**RE: Request for Further Information
Lingard Private Hospital Expansion (SSD-60316710)**

This letter is submitted to the Department of Department of Planning, Housing and Infrastructure in response to the Request for Further Information (RFI) issued on 10 December 2024, relating to SSD-60316710 for the proposed expansion of the Lingard Private Hospital.

DRAWING NO:
DA-400

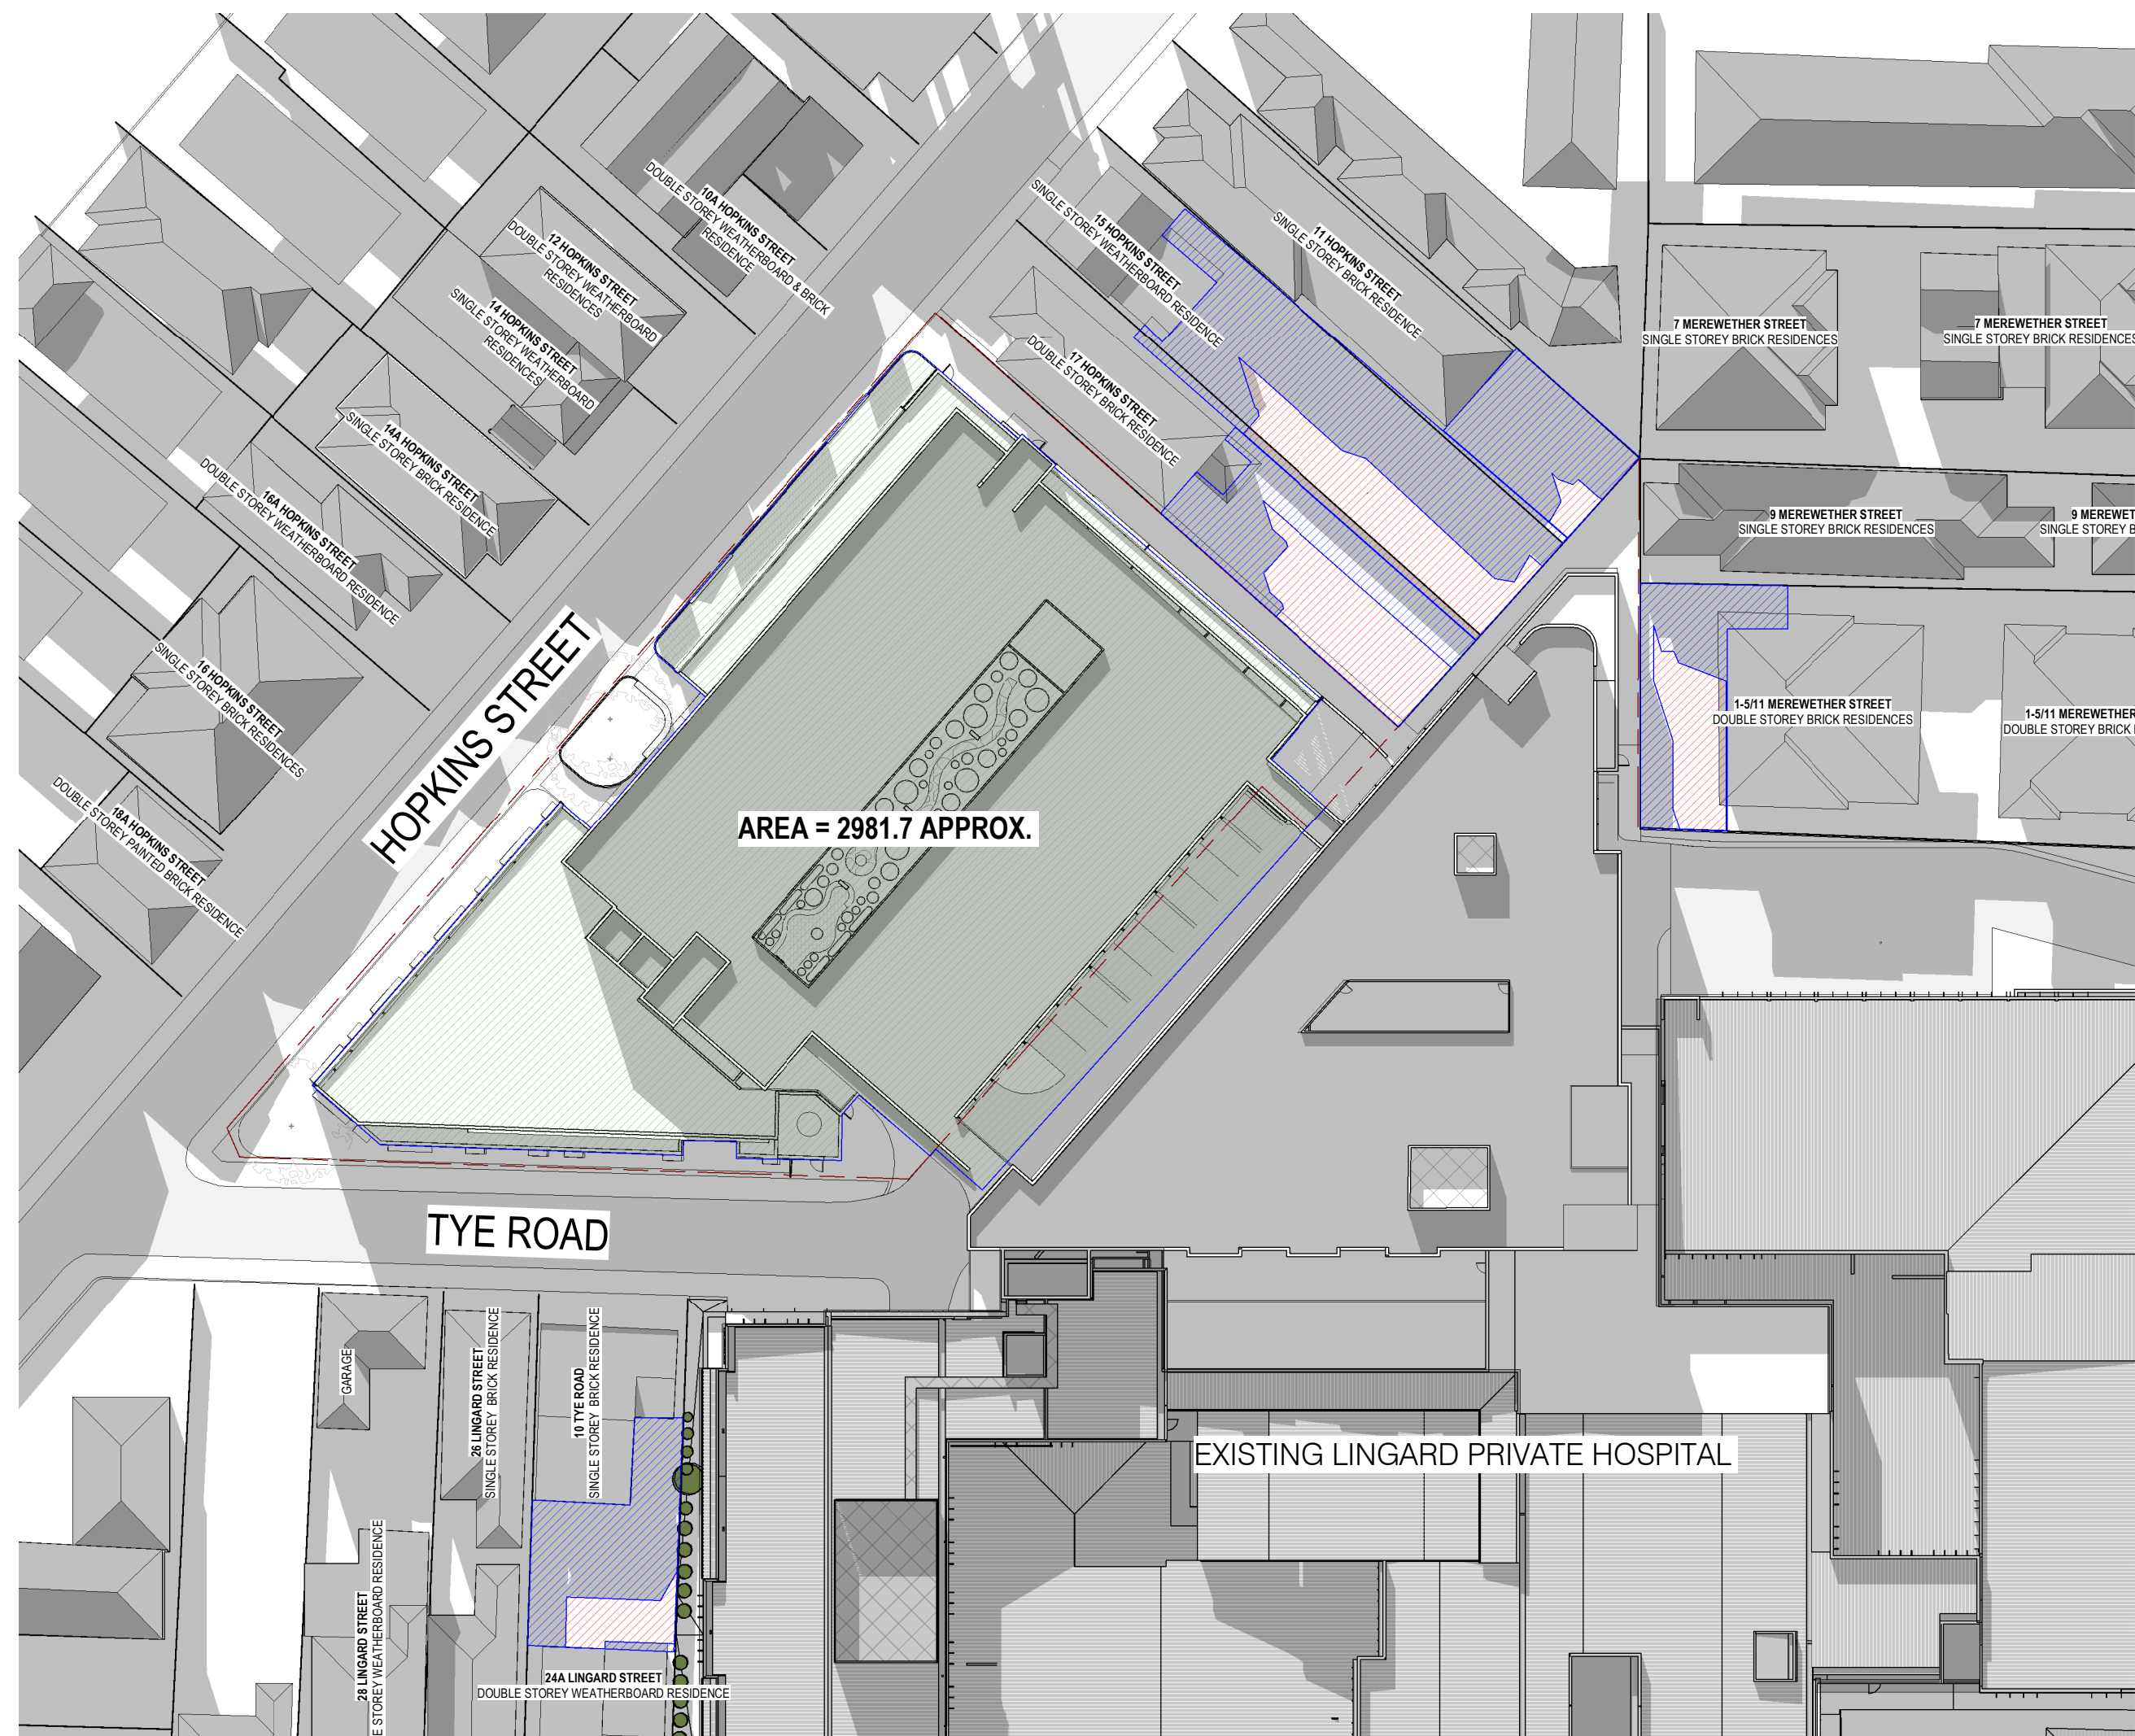
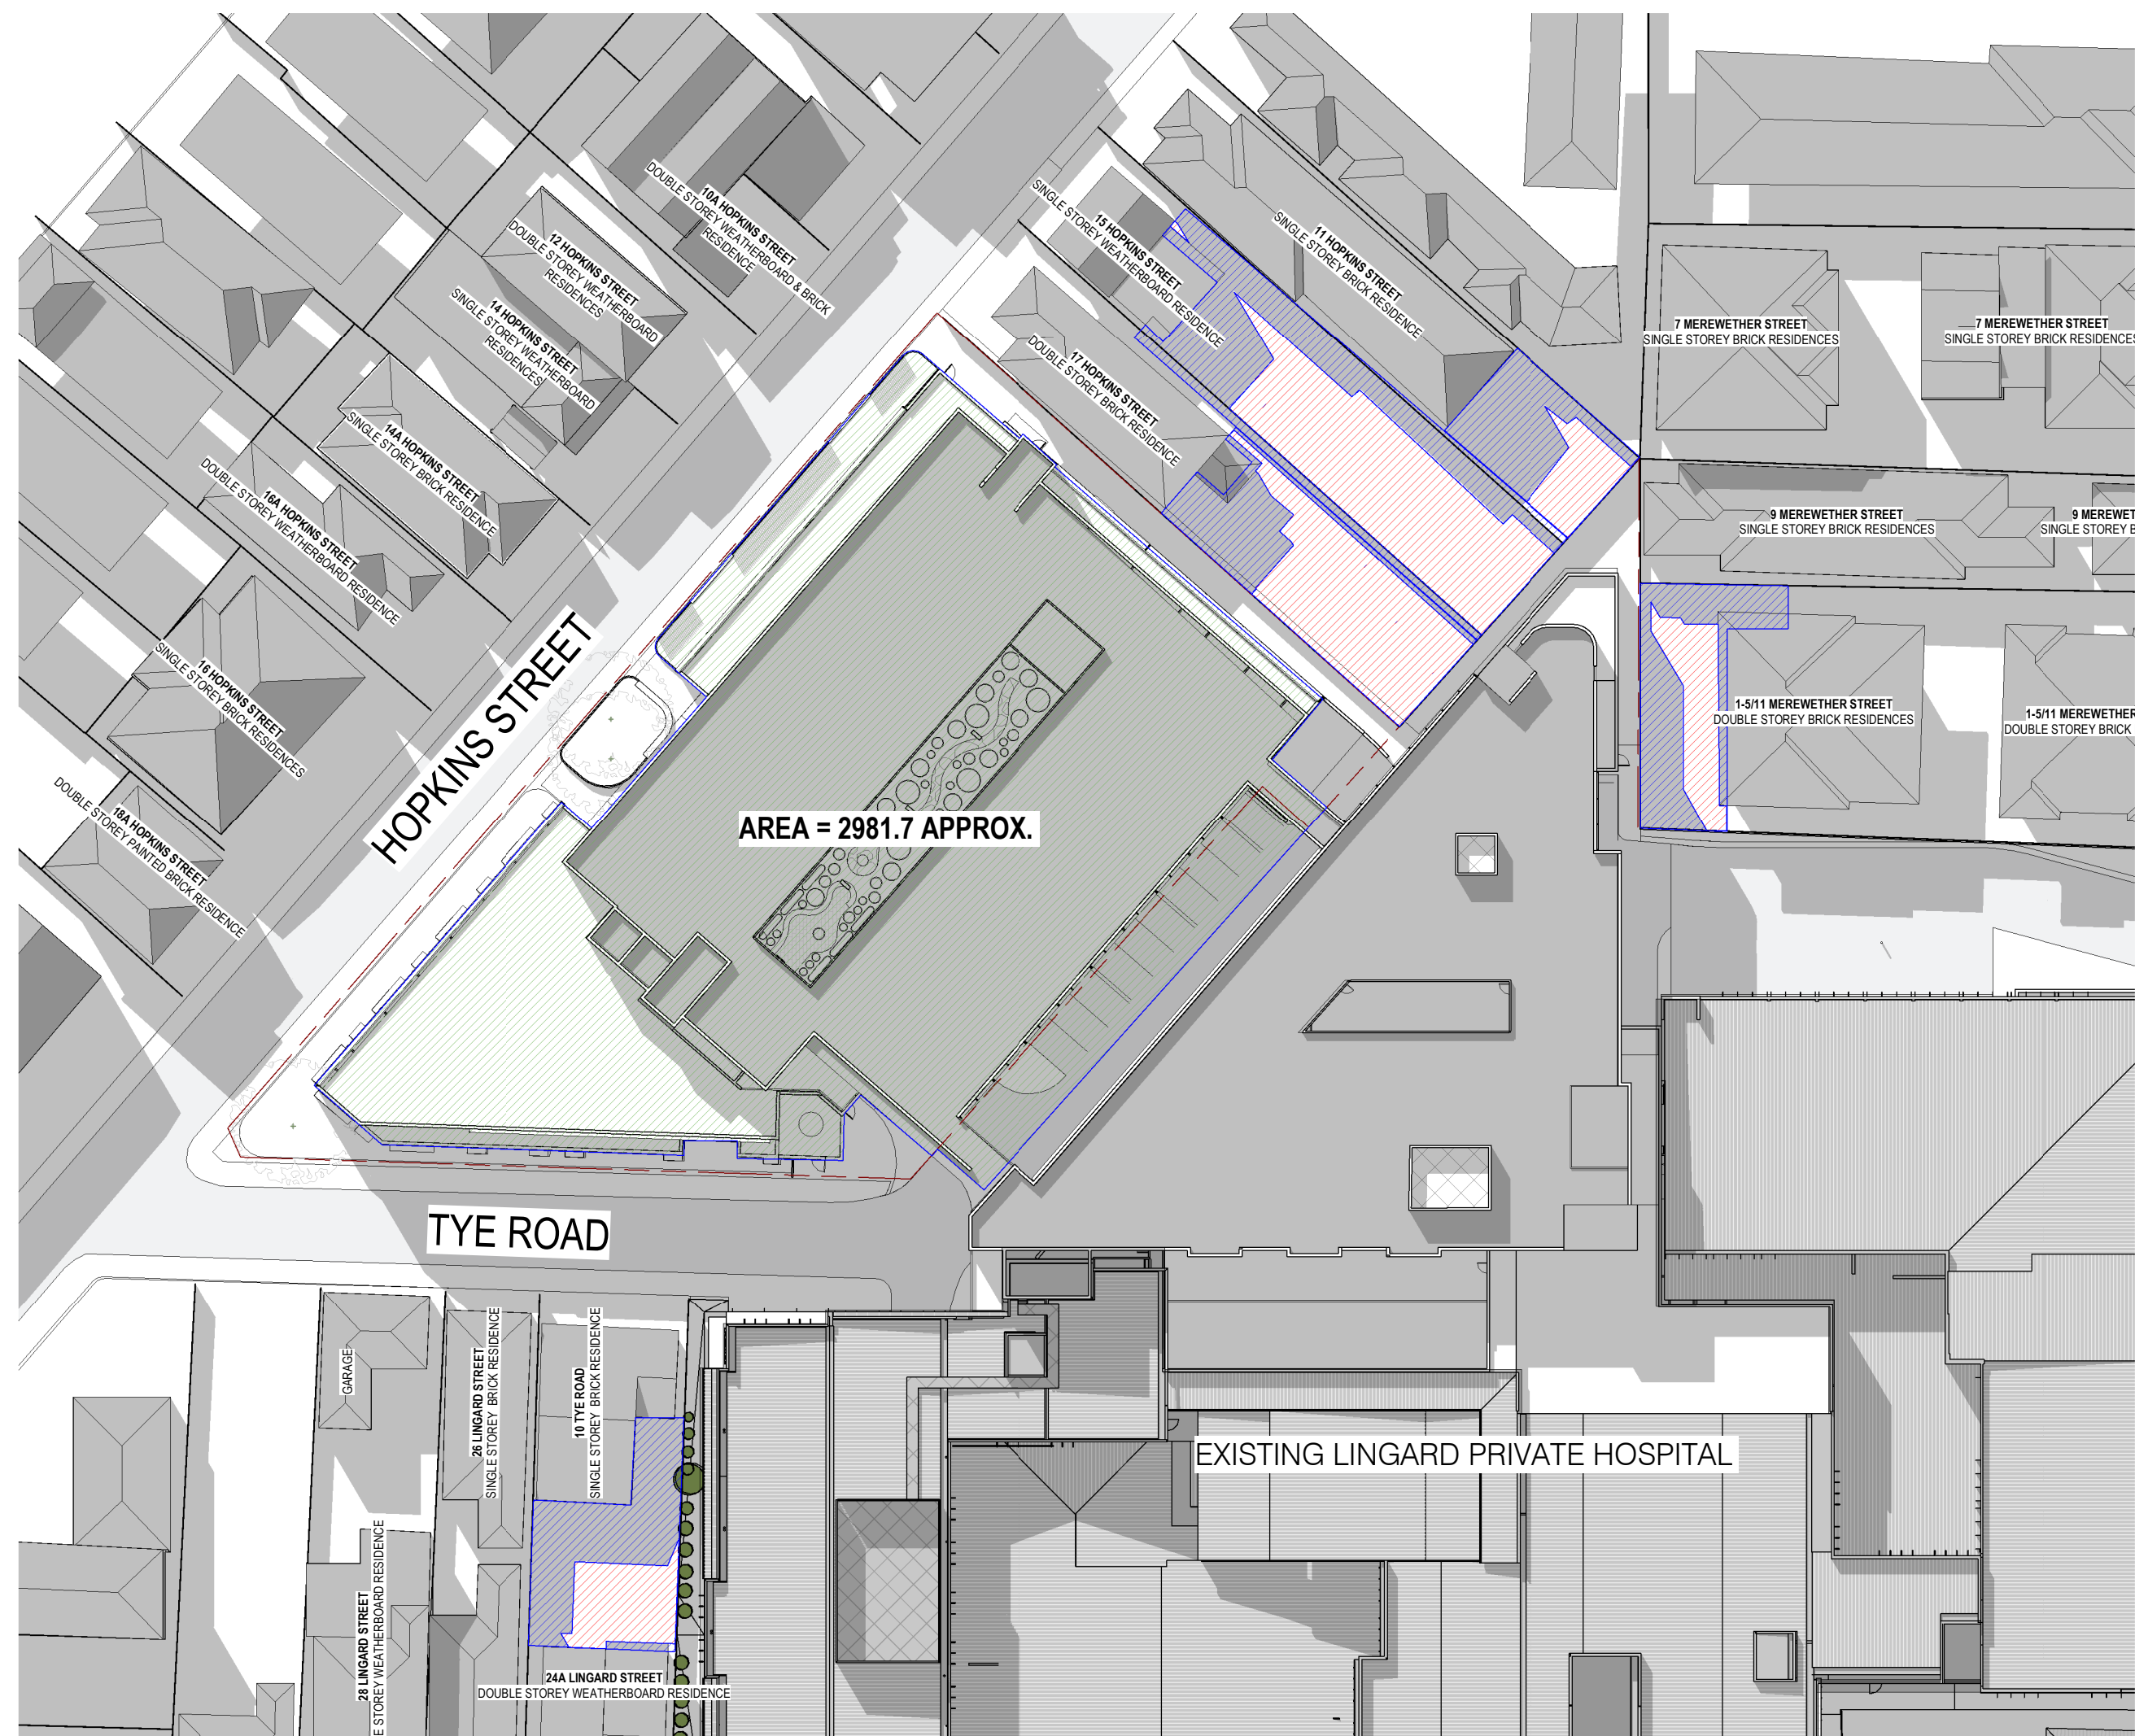
CN's concerns regarding residential amenity remain. The amended architectural plans do not include hourly shadow diagrams or 3D shadow analysis to identify the habitable rooms and private open space of residential properties, as previously requested. The shadow impact to Mitchell Park has not been adequately addressed.

The non-compliant height coupled with reduced setbacks on the eastern boundary of the Hopkins Precinct, exacerbate the amenity impacts. CN recommends the design is amended to reduce the bulk and ensure upper floor levels comply with the setback requirements and maximum building height development standard. CN recommends the applicant is required to submit additional shadow diagrams at hour intervals between 9am and 3pm during the June 21 winter solstice.

Additional shadow diagrams have been provided at Appendix A. The overshadowing of Mitchell Park is minimal, occurring only at 9 AM during winter. The affected area consists of large trees and on-street parking that would naturally be in shadow. The proposal ensures ample daylight reaches the trees and surrounding area at all other times.

The amended shadow diagrams include percentage calculations for the surrounding residential dwellings and confirm compliance. The most significant impact is on 11 Merewether Street in the afternoon; however, the existing shadow diagrams show that this is also the present state, refer to Figure 1 & 2 below. In the previous iteration of plans the second level wall was also setback further from this boundary.

The proposal does affect the adjoining Hopkins Street dwellings at 3 PM; however, there is no impact during the morning hours. The proposed setbacks are consistent with the existing dwelling setbacks in the area. While there is some overshadowing in the afternoon, the dwellings receive sufficient sunlight in the morning,

Overall, the proposed height variation does not result in any unreasonable adverse impacts on neighbouring properties in terms of bulk, scale, overshadowing, or privacy. The minor exceedance is justified by the functional necessity of the affected building elements and their limited contribution to the overall form, ensuring a well-balanced outcome that meets the intent of the planning controls while supporting high-quality urban design. Additional shadow diagrams are provided at Appendix A.
